16 March 2016

Subject: One Carrington Street – Response to Section 96 modification comments

02 Typical Office Plan  
1:25

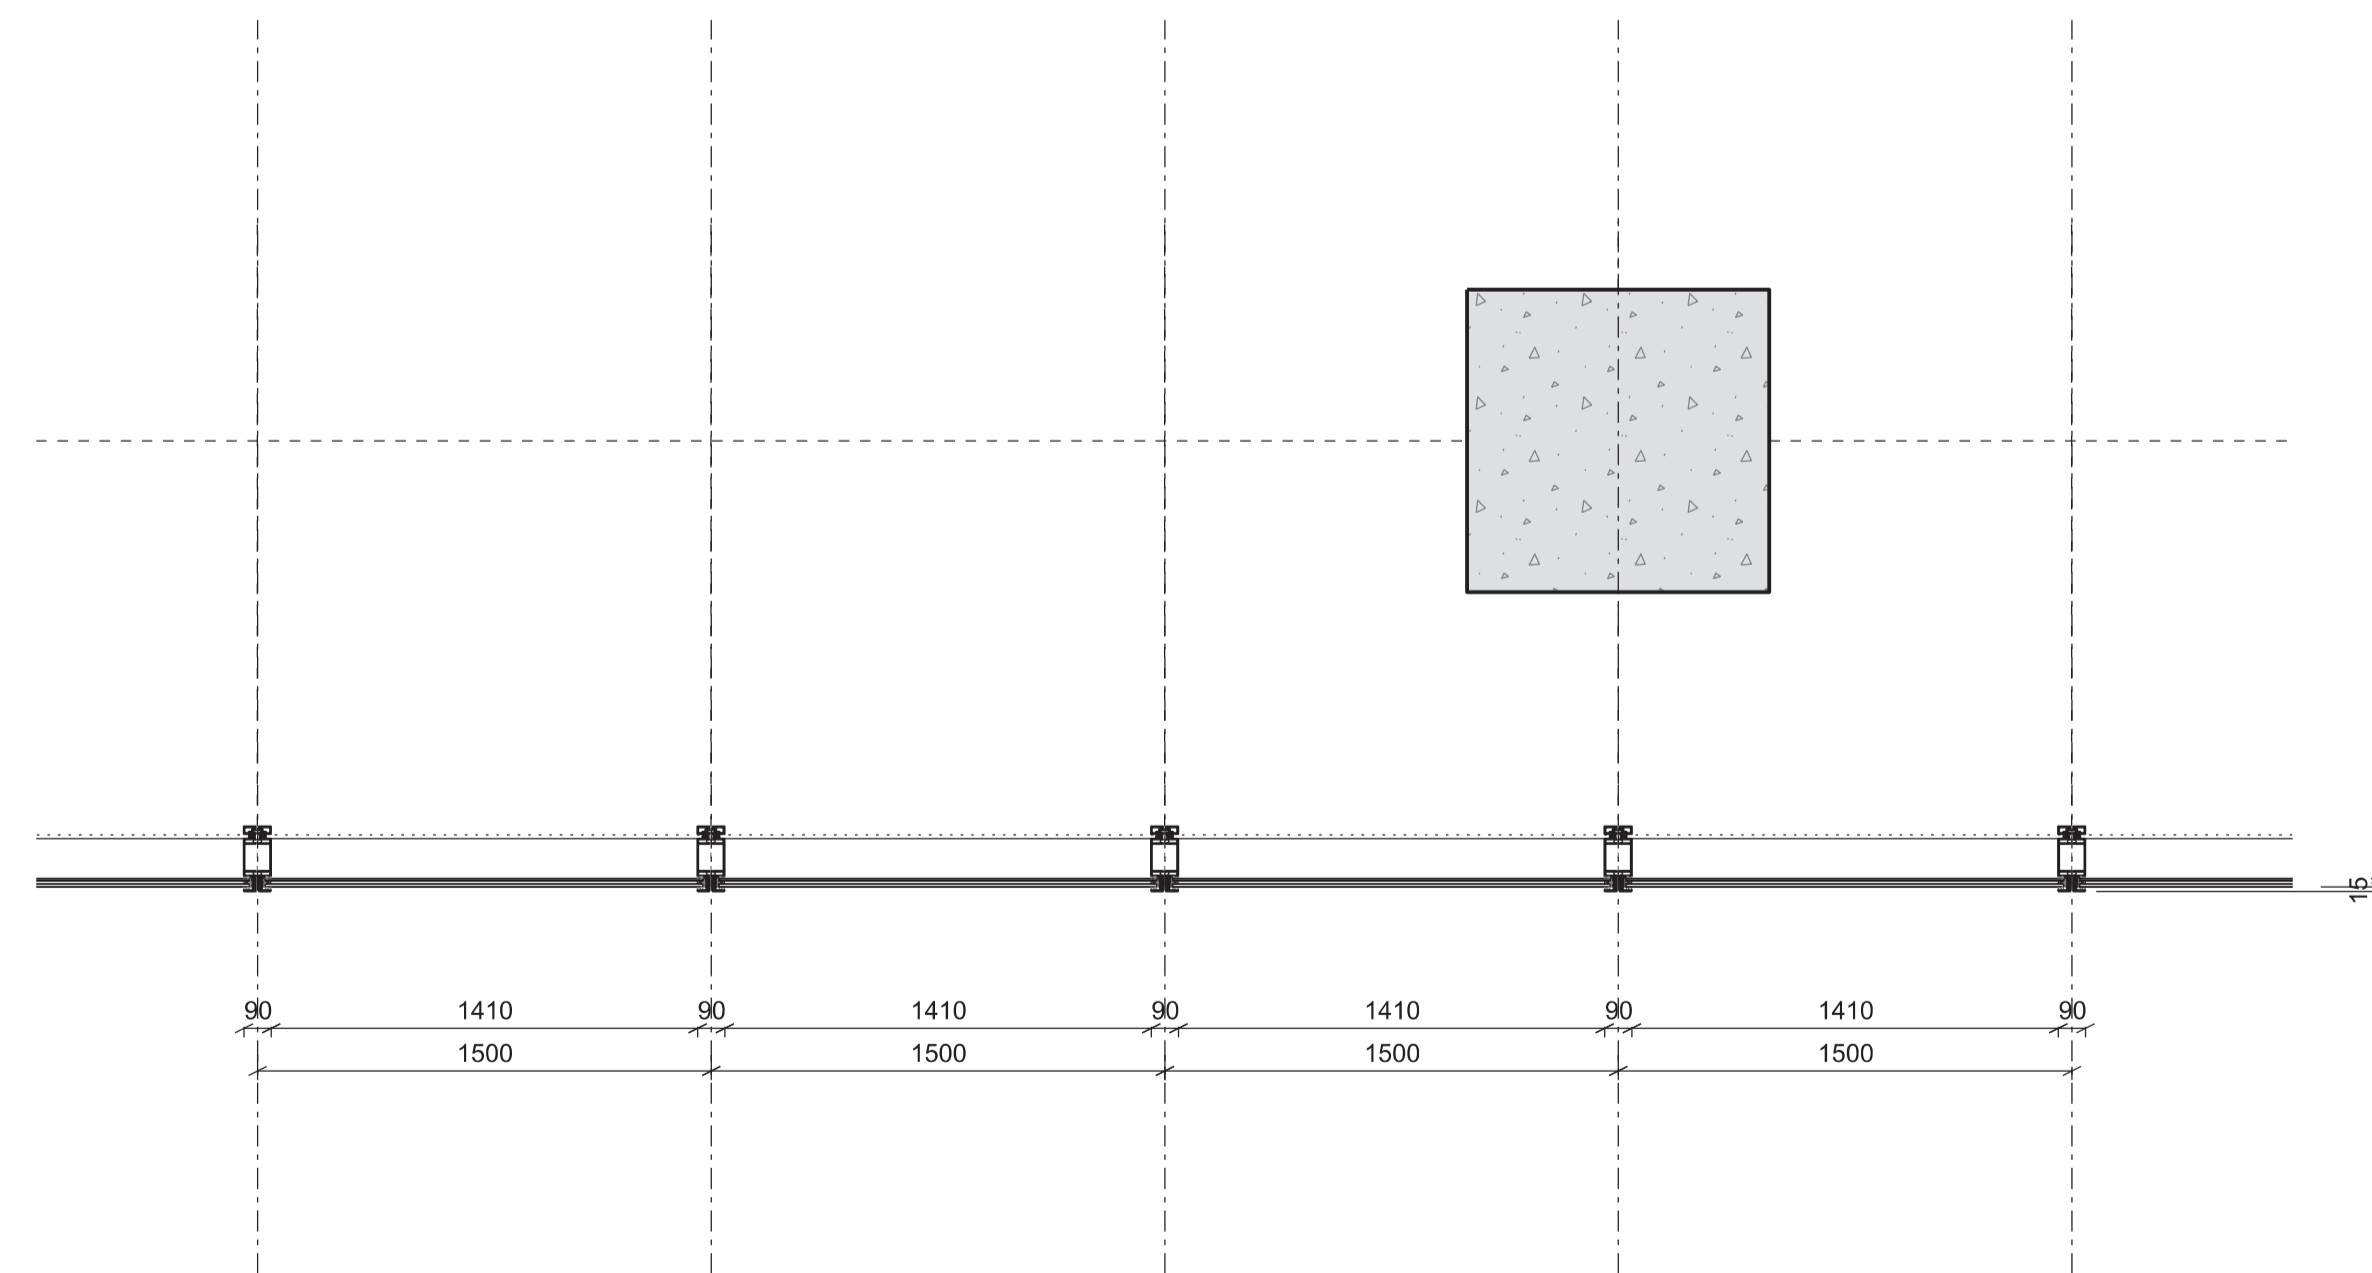
As the Department has pointed out the 15mm capping will not read as a fin, however, as illustrated in the renders, the 15mm does provide fine grain articulation to the facade which ties it in with the overall materiality and architectural expression of the building.

The views demonstrate that the part of the building which the 15mm façade type applies to only presents a slender façade to the primary frontages of Carrington Street and George Street and will therefore always be seen in the context of the other façade types. Its predominant frontage is to the south, however as the views from the public domain illustrate, this frontage will not be viewed front on and is largely obstructed by other buildings. In particular we note that 333 George Street is under construction and will completely obstruct views from street level south of Martin Place.
